Jeanie Bourke - Re: Resubmittal

From: Jeanie Bourke
To: Jamie Grattelo; Tammy Munson
Date: 9/12/2014 9:23 AM
Subject: Re: Resubmittal
CC: Jim Grattelo; Jonathan Rioux

PRELIMINARY LIFE SAFETY PLAN

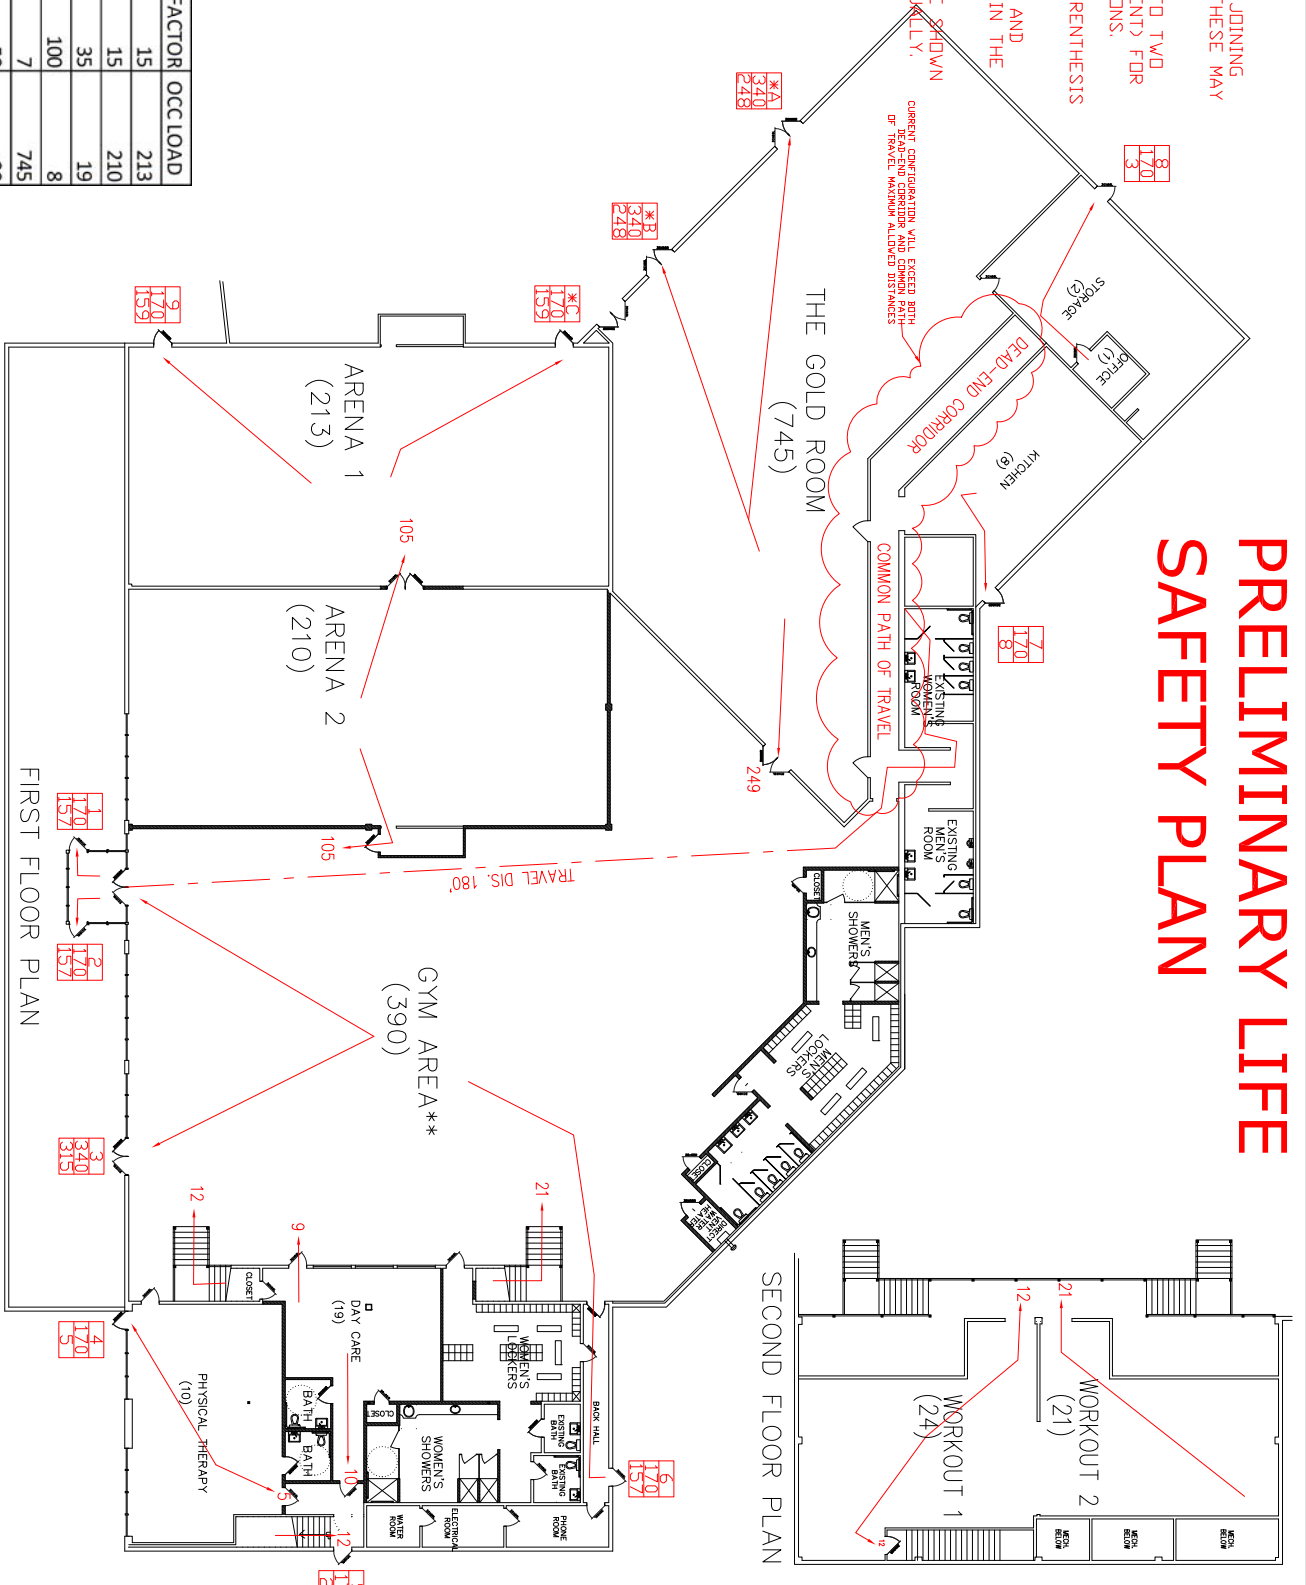
3. Provide a (For Construction rather than Preliminary) compliant Life Safety plan, this plan shows dead end and common path of travel issues. Please address these and re-submit.

I was told originally that the prelim one we sent was good enough to start moving forward. Carol has committed to finishing this for us and I am confident it will be more than acceptable she just can't do this for at least a week.

FLOOR PLAN
PORTLAND SPORTS CENTER
WARREN AVENUE PORTLAND, MAINE

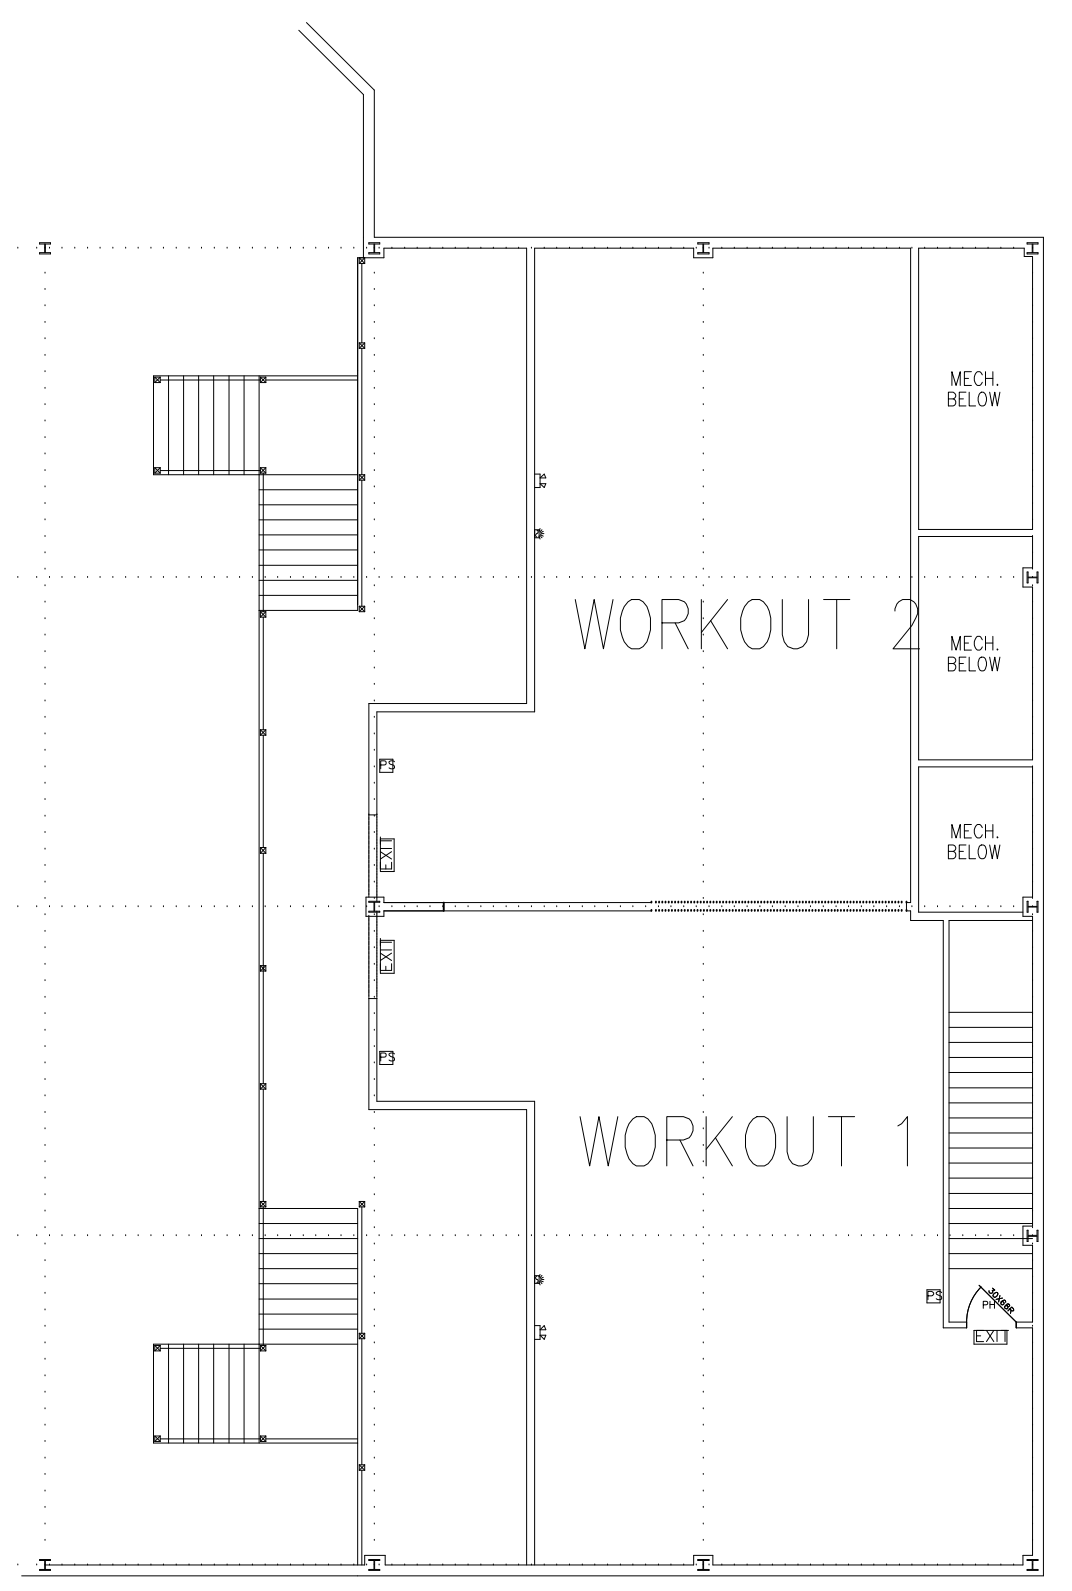
7. On the CAD drawing provide the location of the Drinking Fountain

We have submitted the drinking fountains on the plans
